**St Anthony of Padua Catholic School Redevelopment Modification 1 (SSD-8865-Mod-1)
Response to Submissions**

I refer to the Response to Submissions (RTS) submitted for the St Anthony of Padua Catholic School Redevelopment Modification 1 (SSD-8865-Mod-1). The Department is requesting you provide additional information before accepting the RTS.

ATTACHMENT 1 – ADDITIONAL INFORMATION REQUIRED

Project Number
19-0185
Drawing Number
AA0006

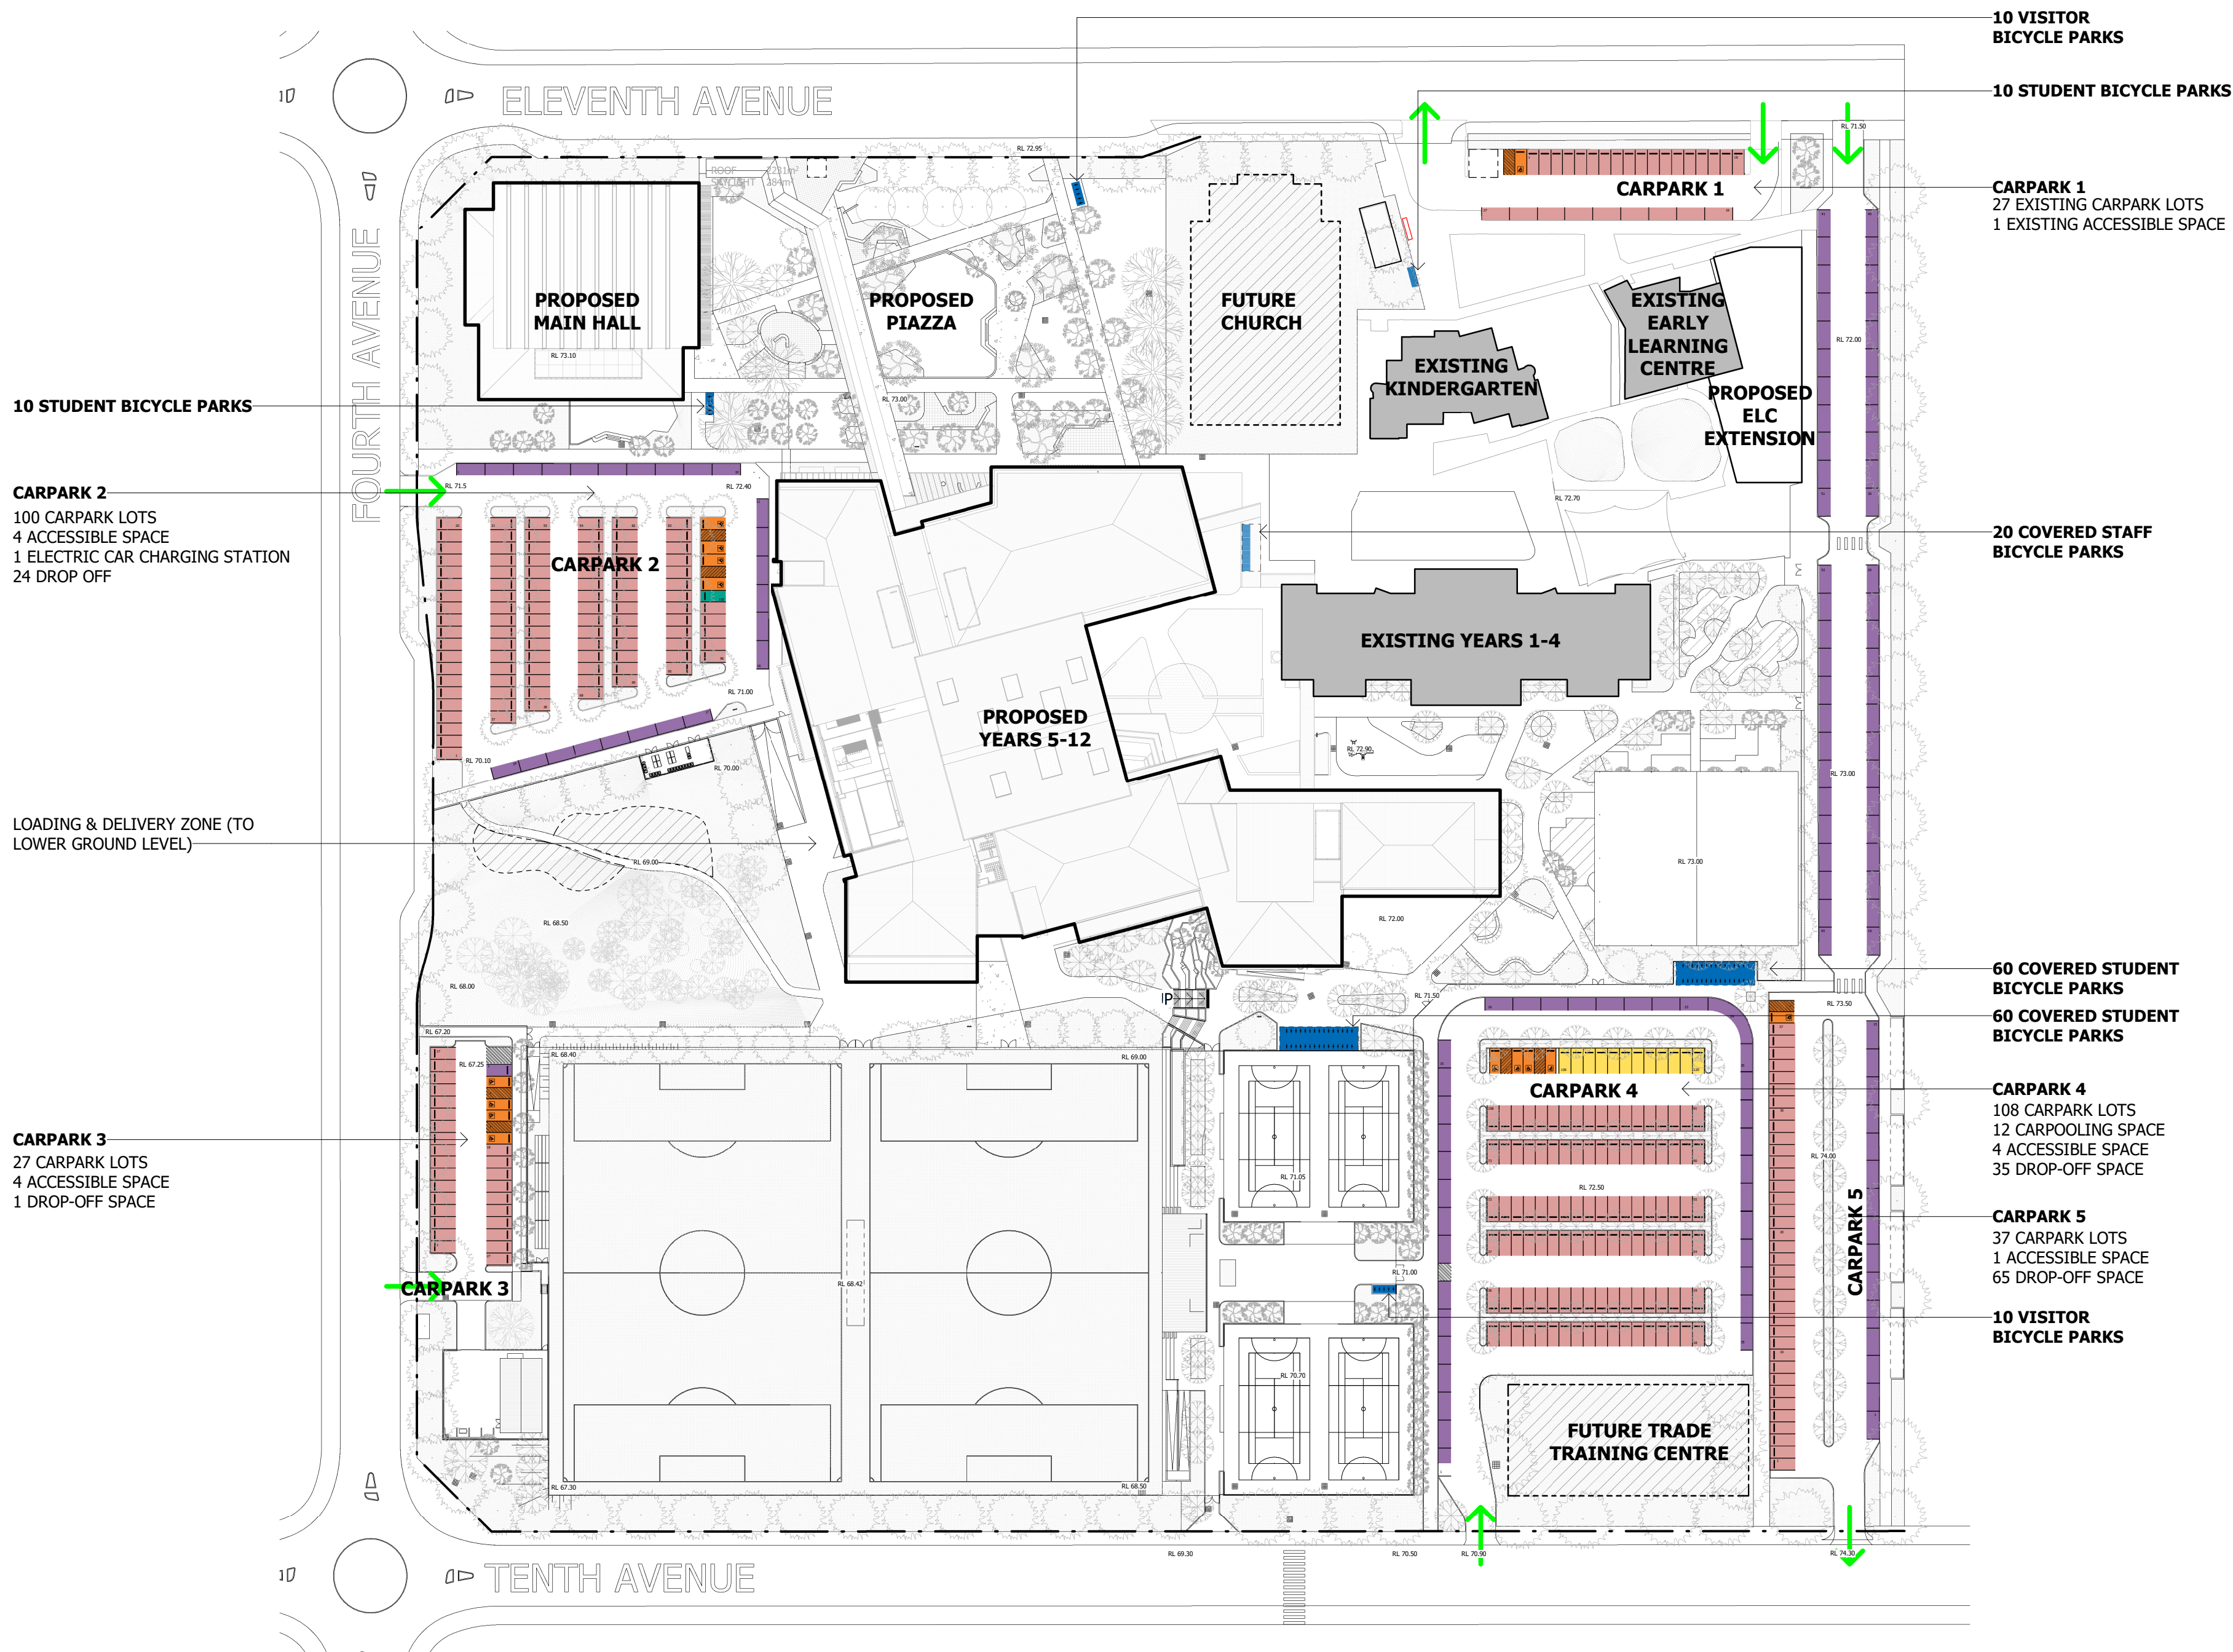
9. With regard to the Department's enquiry regarding the differing figures provided in the proposed Condition B8 Table 1 ('Phase 1' versus 'Existing'), it is noted that the approved Phase 1 figures for car and bicycle parking spaces were intended to reflect the existing provision on site. However, if these spaces were previously existing at the site, this does not explain why the number of 'existing' spaces outlined within the modification application are lower than those previously identified. Please clarify the difference. For example, have some of the previously identified spaces since been removed? Should this be the case, you will need to explicitly advise that this aspect of the development is subject to a retrospective modification request (see Point 2).

PHASE 1

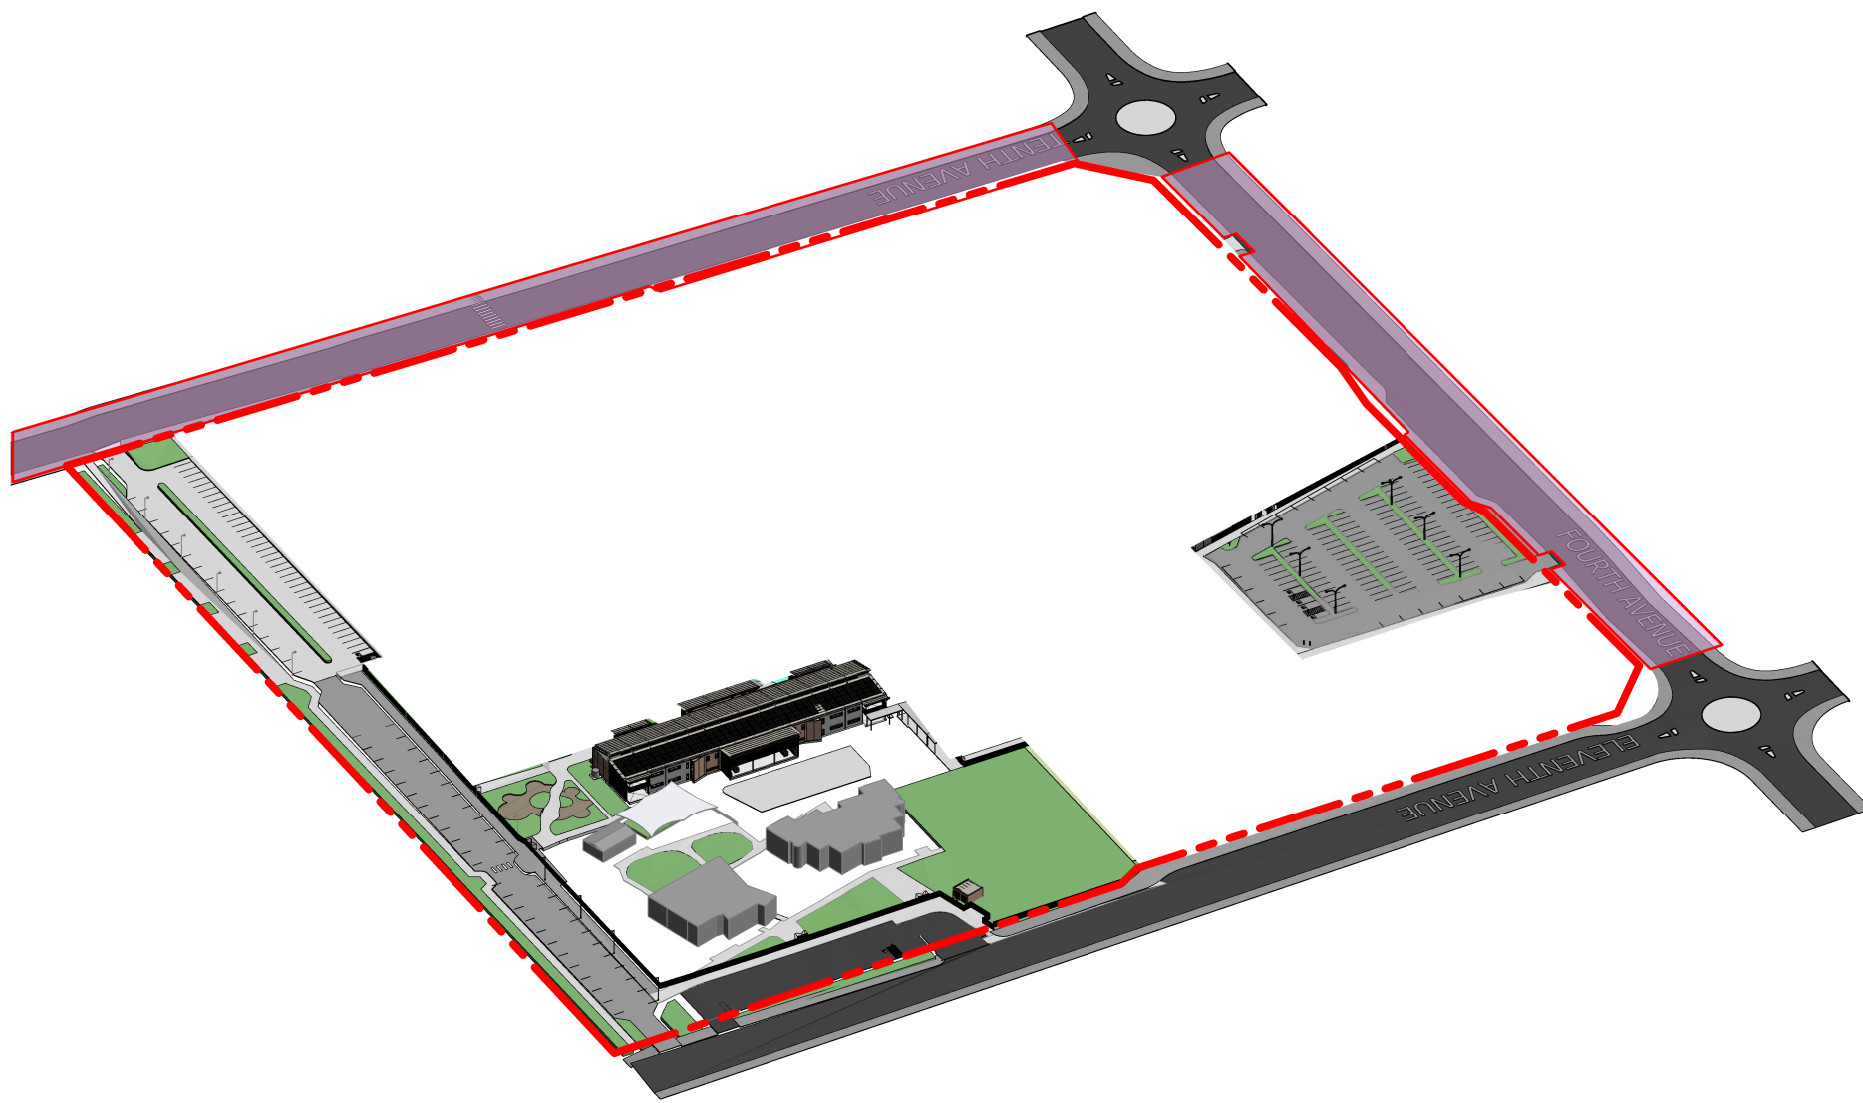
8. The Years 1-4 building is still shown inconsistently on the plans. For example, it is shown as 'existing' on some plans. For consistency and to avoid any confusion regarding the approval pathway for the building, each plan must indicate that the building is included as part of Phase 1 works.

AA2070
E

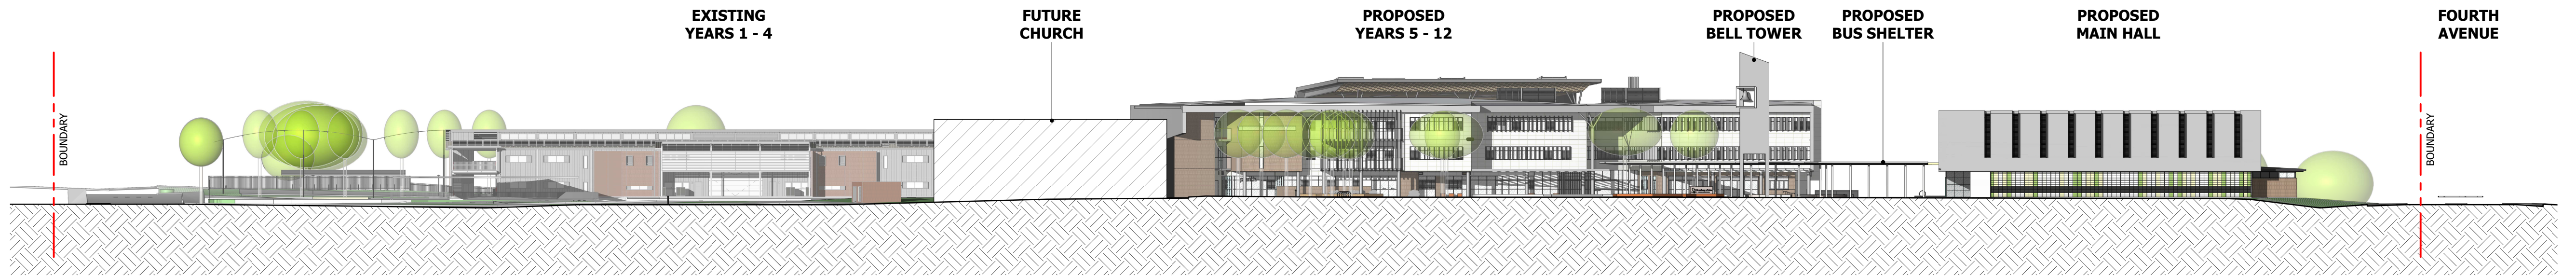
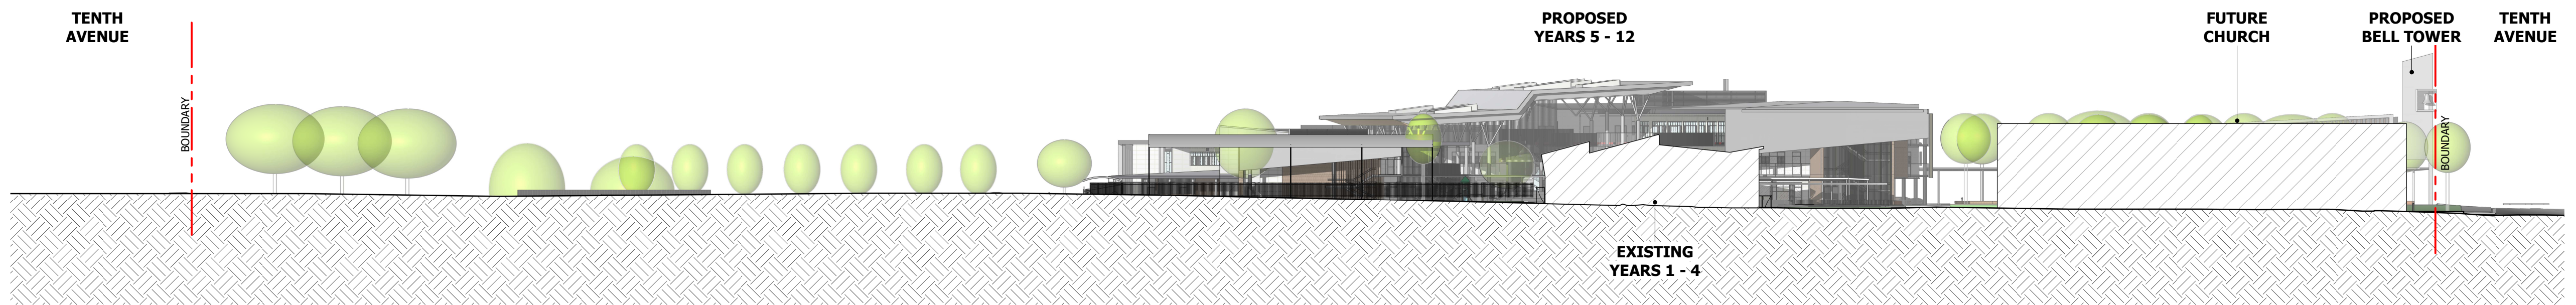
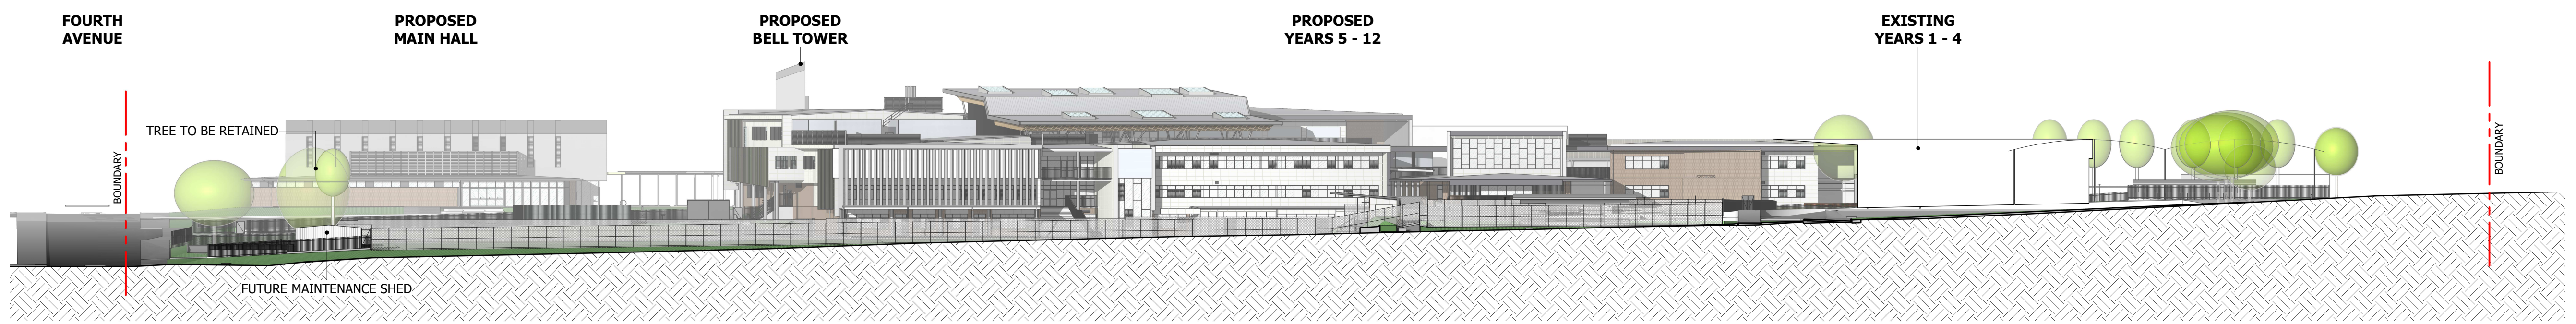
10. All architectural drawings must show RL level to top of roof and rooftop services, as consistent with the approved drawings. For example, the height of the roof of the main school building appears to extend beyond roof level RL shown on the plan.
